Y/68/22/L

Berri Court Main Road Yapton BN18 0ED

Erection of detached workshop, gym/hobby and greenhouse. This application affects character and appearance of the Main Road/Church Road Yapton Conservation Area and a Listed Building.

ALITEX [®]		TITLE NATIONAL TRUST GREENHOUSES THE WIMPOLE WITH SPECIAL BENCH. (NT-WIMP-ST-R-D-C-X-RAL 9005)		
DRAWN LC	DATE 23/02/22	SCALE 1:50 @ A3	DWG NO. NT/HARD30539_GP. Sheet 1 of 2	REV -
CHECKED NR 24/2/22	No. Berricourt.		30539

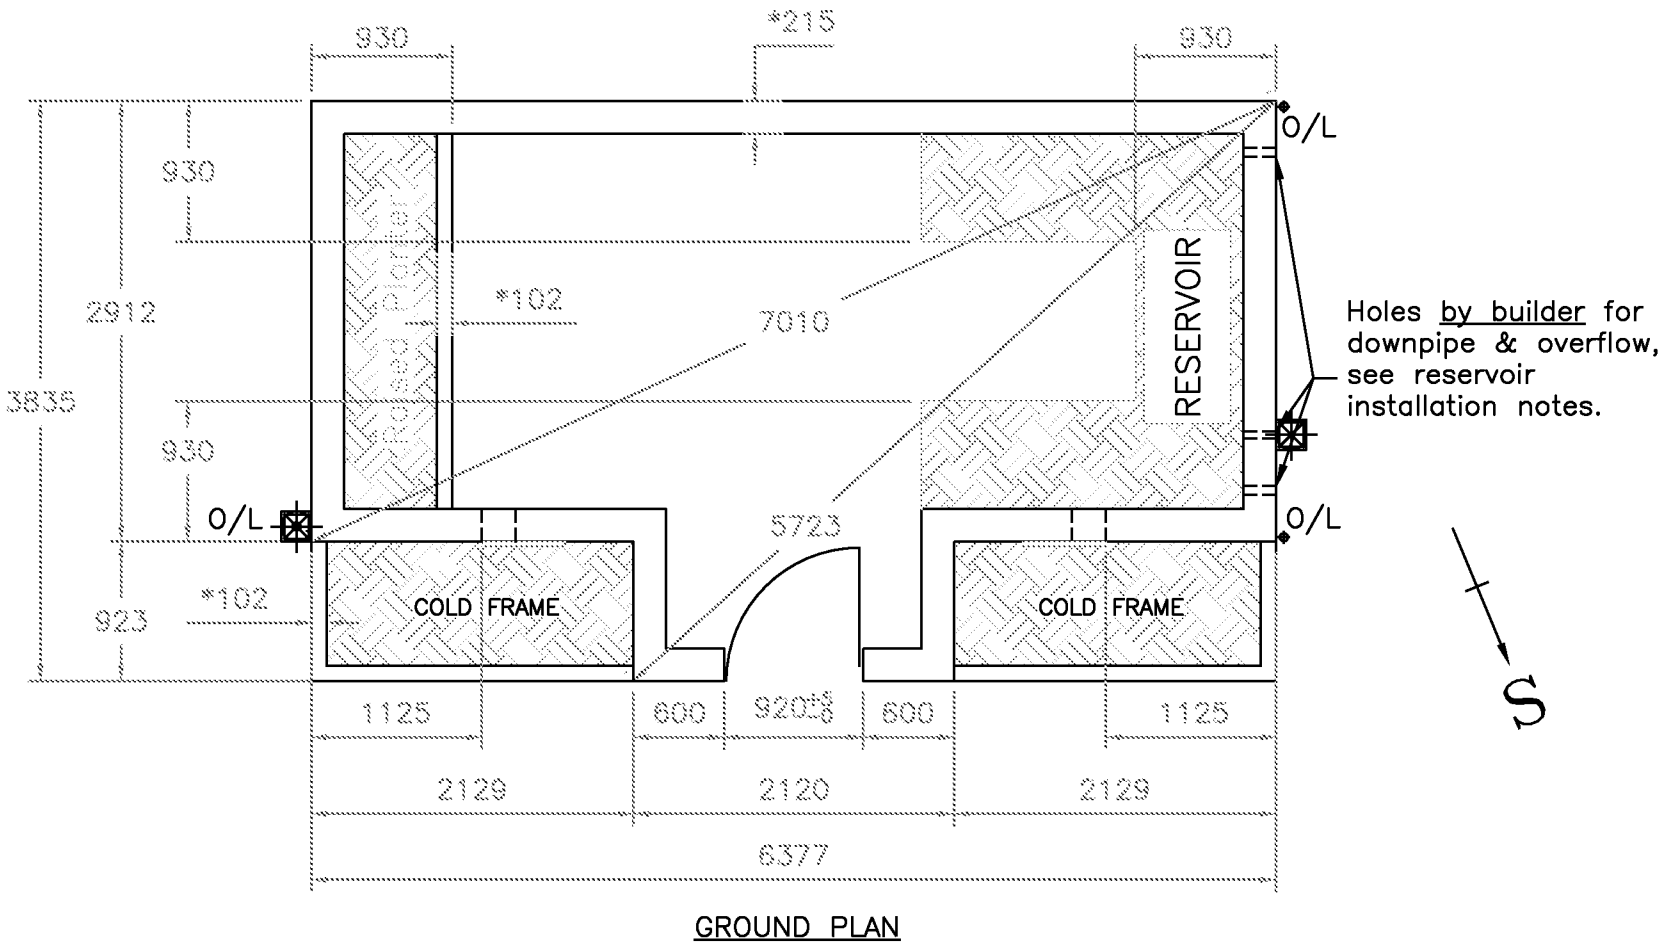
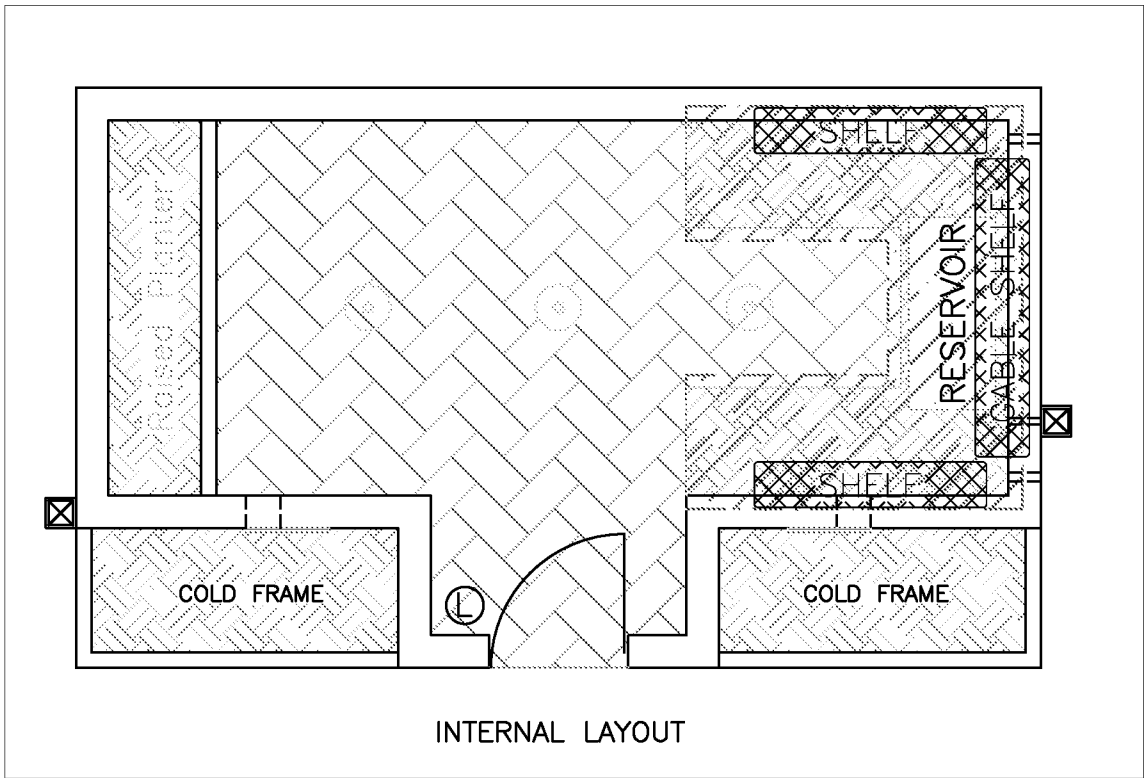
The glass house is of a more traditional design, and like the other two structures would have a neutral impact.

Title
SITE PLANS

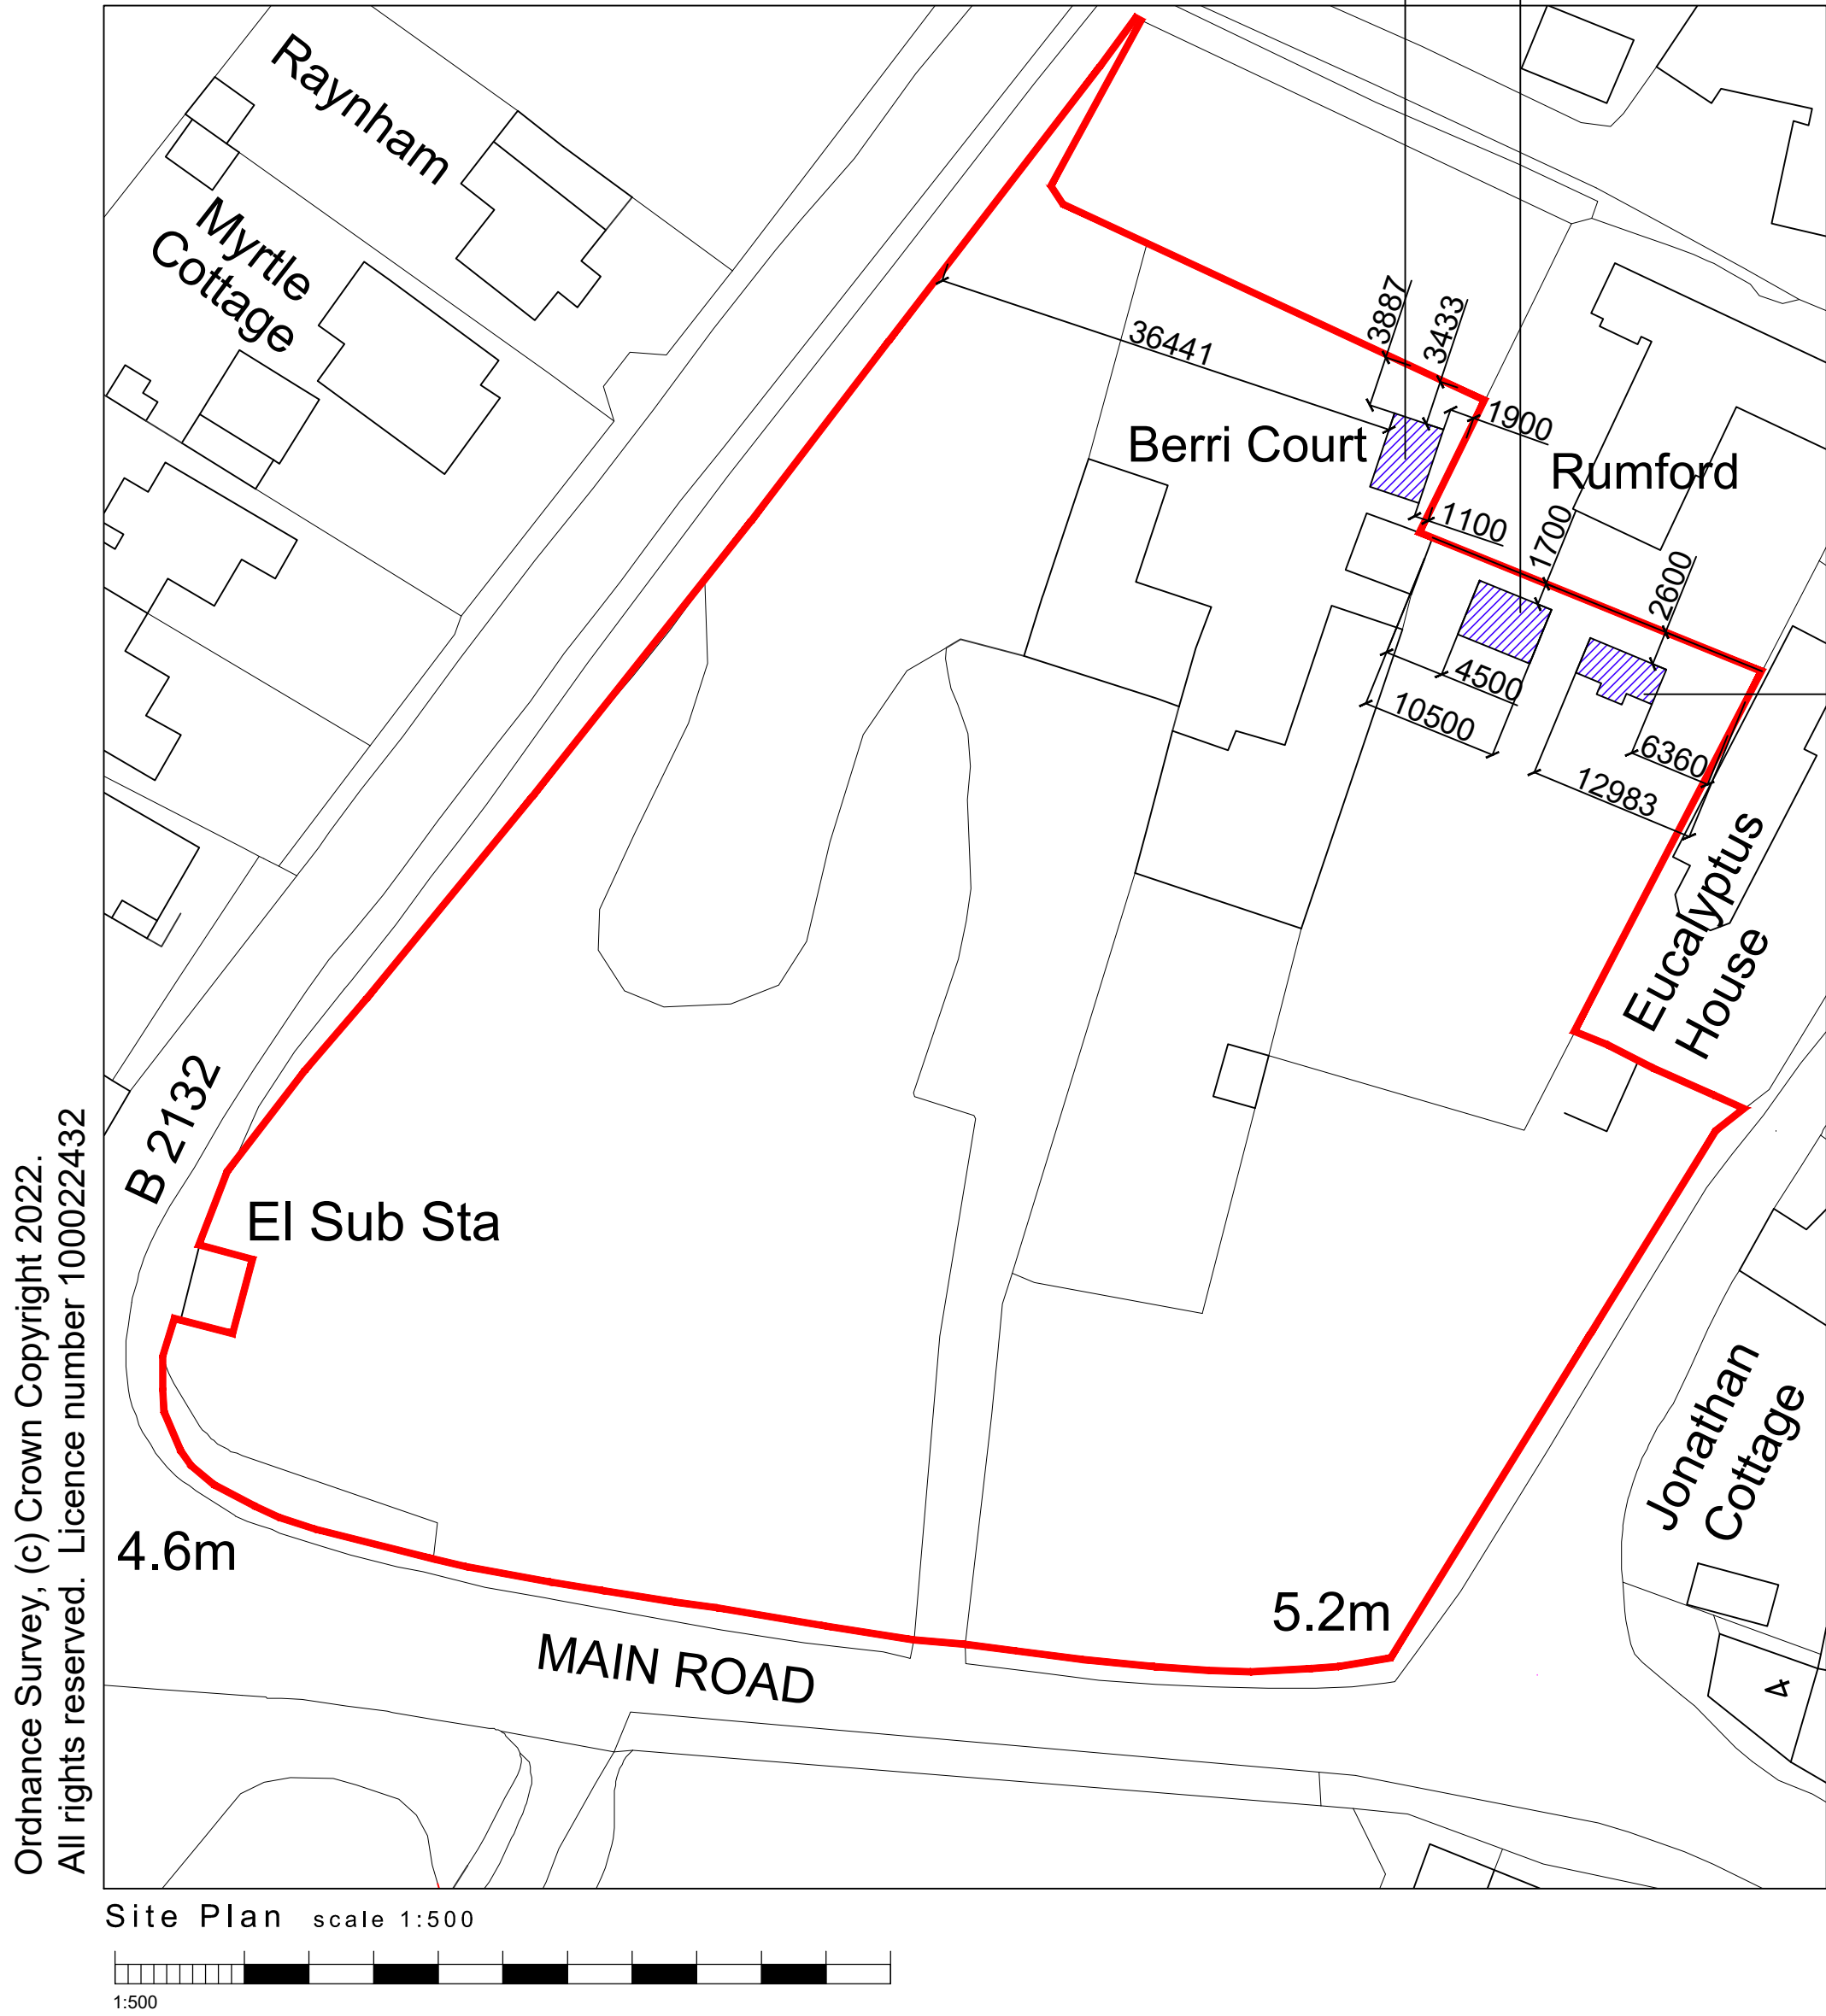
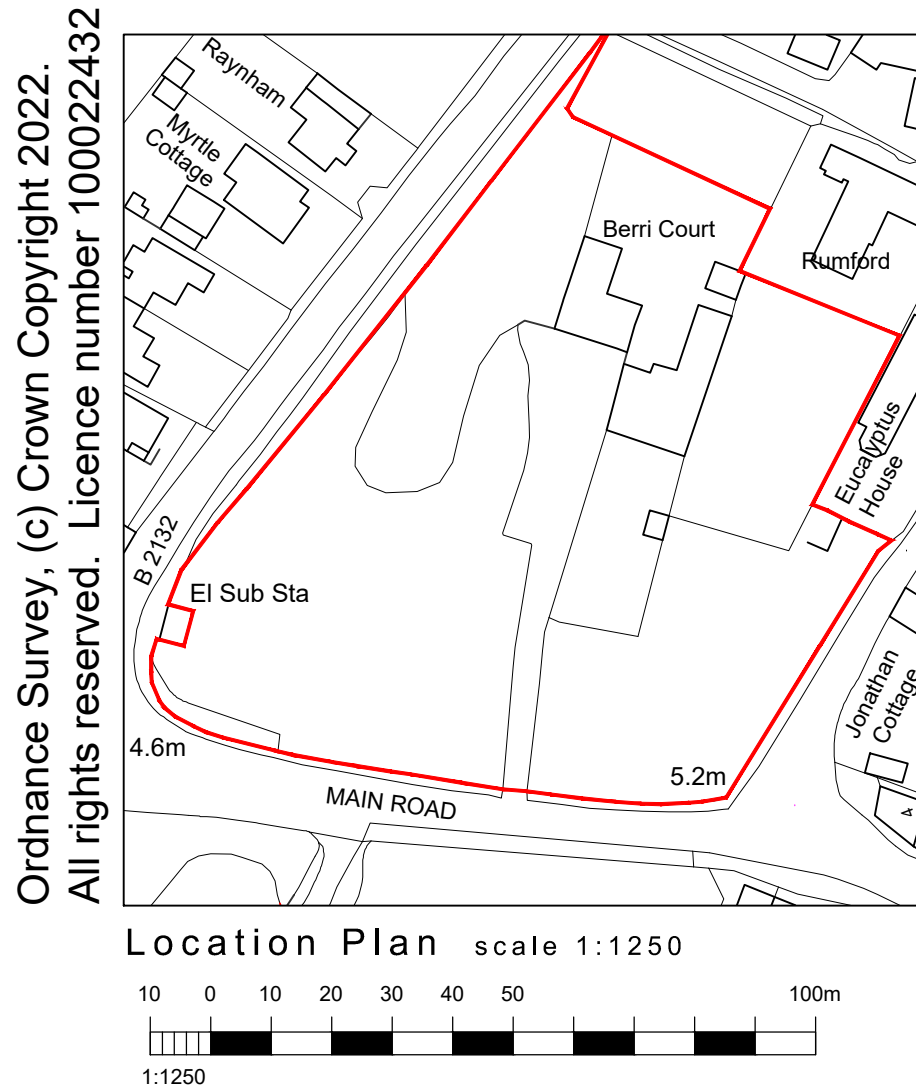
The greenhouse and the workshop structure would be located to the side of the house within a walled garden; the northern, eastern and southern boundaries of this space are walling, whilst the western one is predominantly the listed building itself. The structures would back onto an existing wall and the gym and workshop would form a small group with an existing building. The presence of existing screening/walling means that the location of the structures would not be clearly seen

from the main roads in the conservation area, and it is considered that the plans are slightly misleading in this respect.
